MICAH JEUB
 GLAMPING II
 SITE DEVELOPMENT PLAN

File Number: PPR2433

# SUBSTITUTE LANDSCAPE PLAN

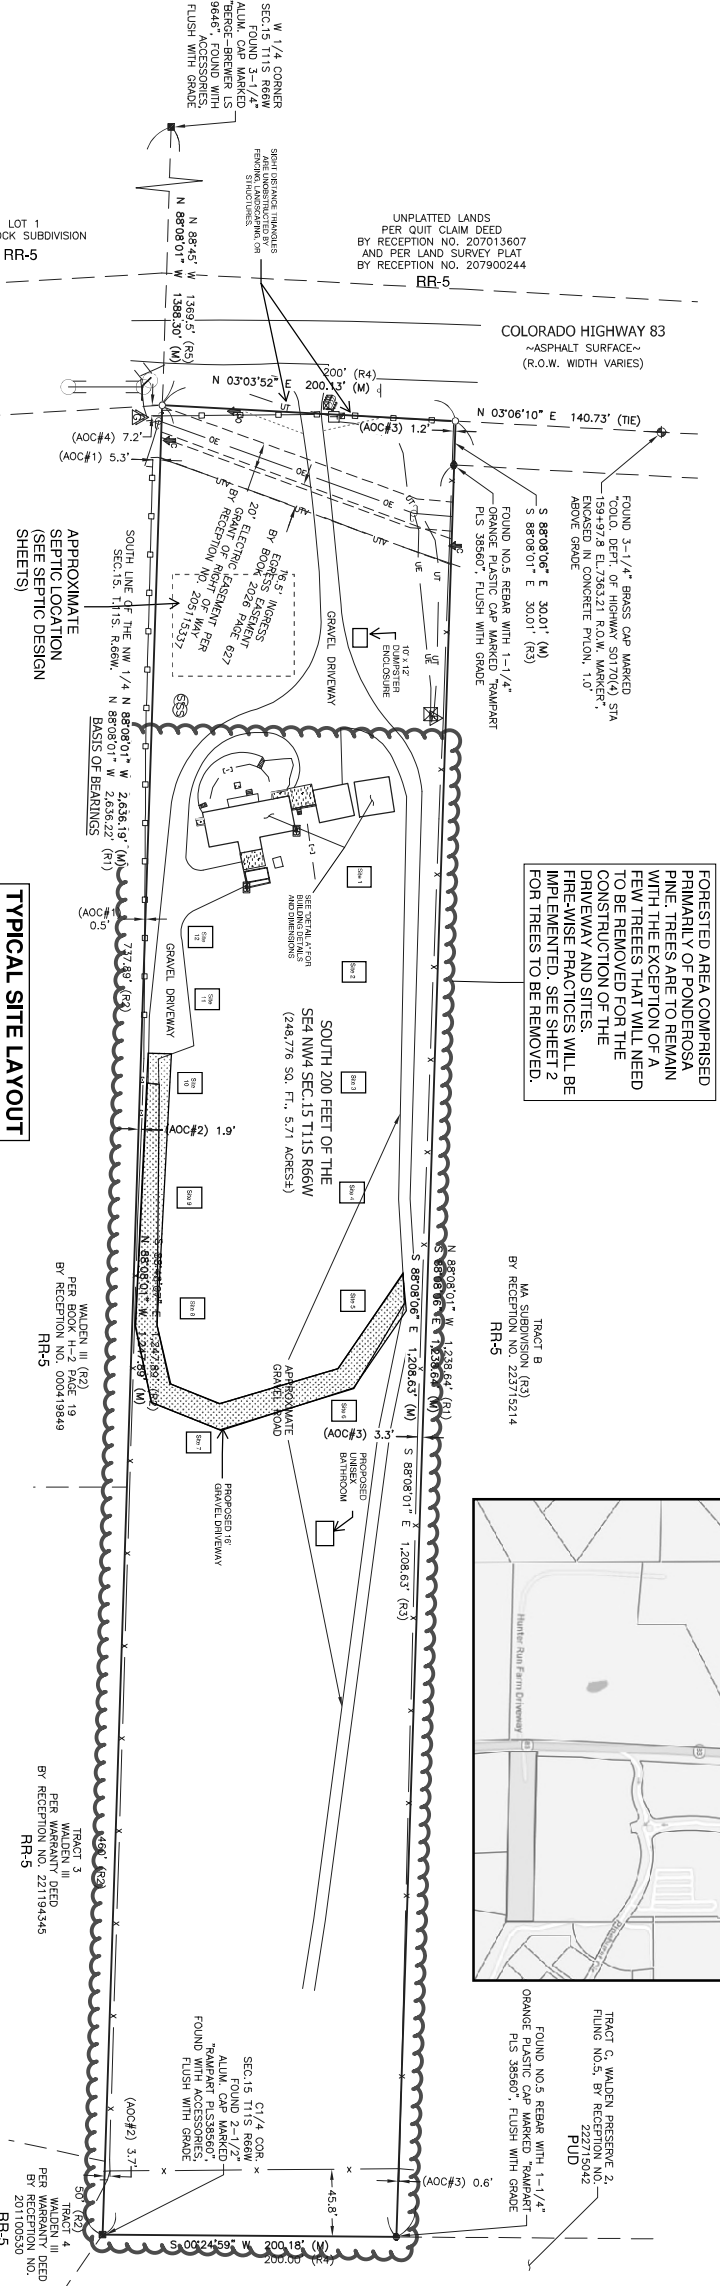
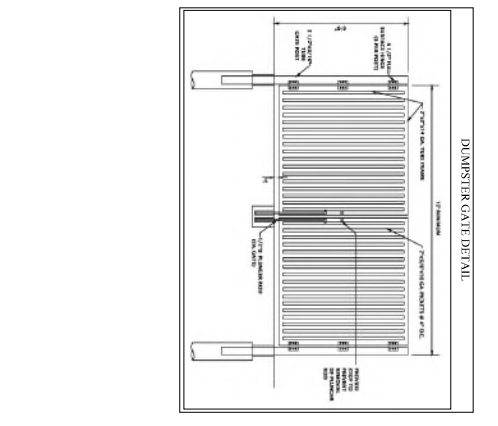
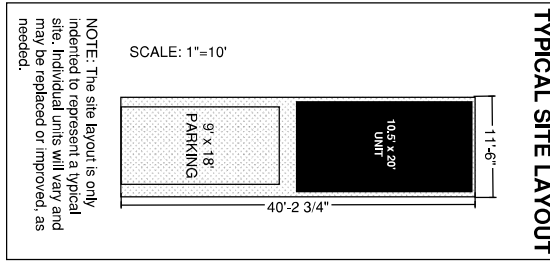
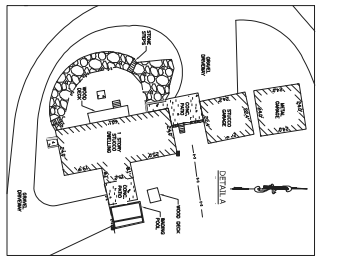
Please include:
 -Title document "Substitute Landscape Plan"
 -Indicate the percentage of coverage on site via trees/ "landscaping"
 Notes:
 -This is phase 1 of phase 2 of the Site Development Plans associated to Special Use approval AL2318 and each phase is for 12 sites only.

PROJECT NO. PPR2433	SHEET 2
DATE 08/14/24	APPROVED CAD
PREPARED NRR	APPROVED CAD

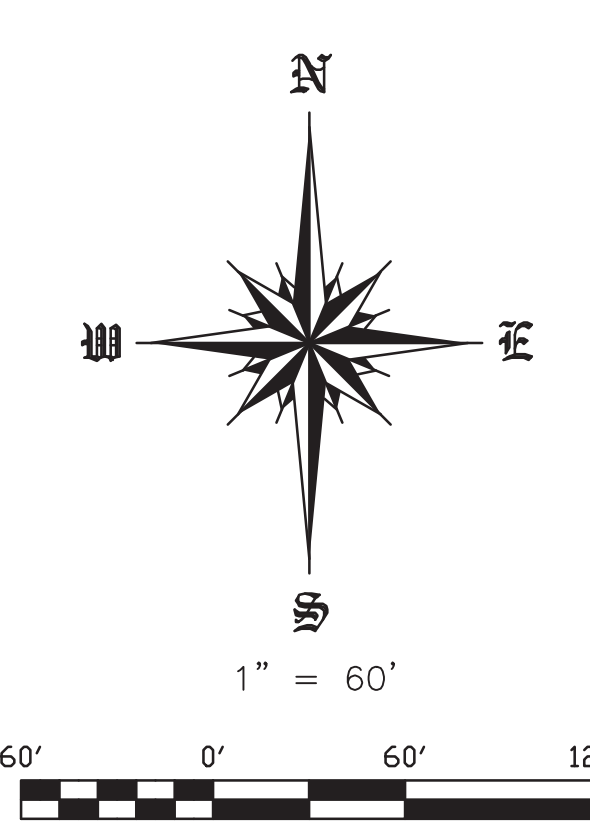
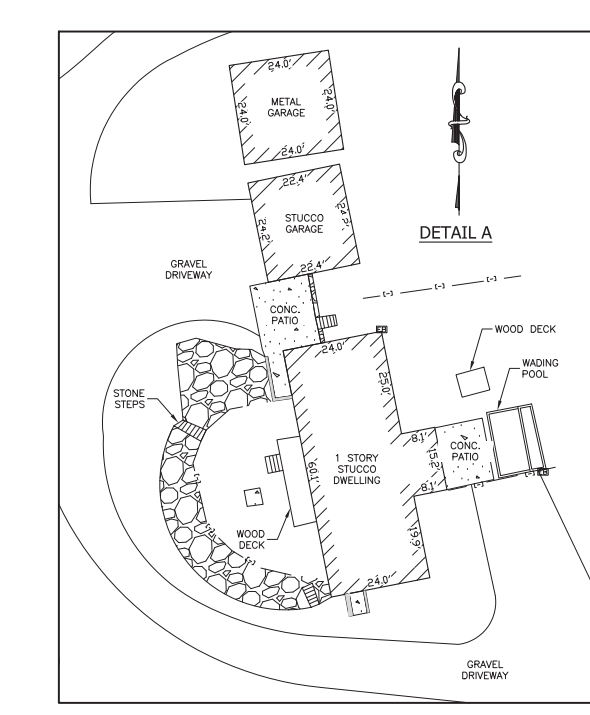
TREES TO BE REMOVED
FOR DRIVEWAY
CONSTRUCTION
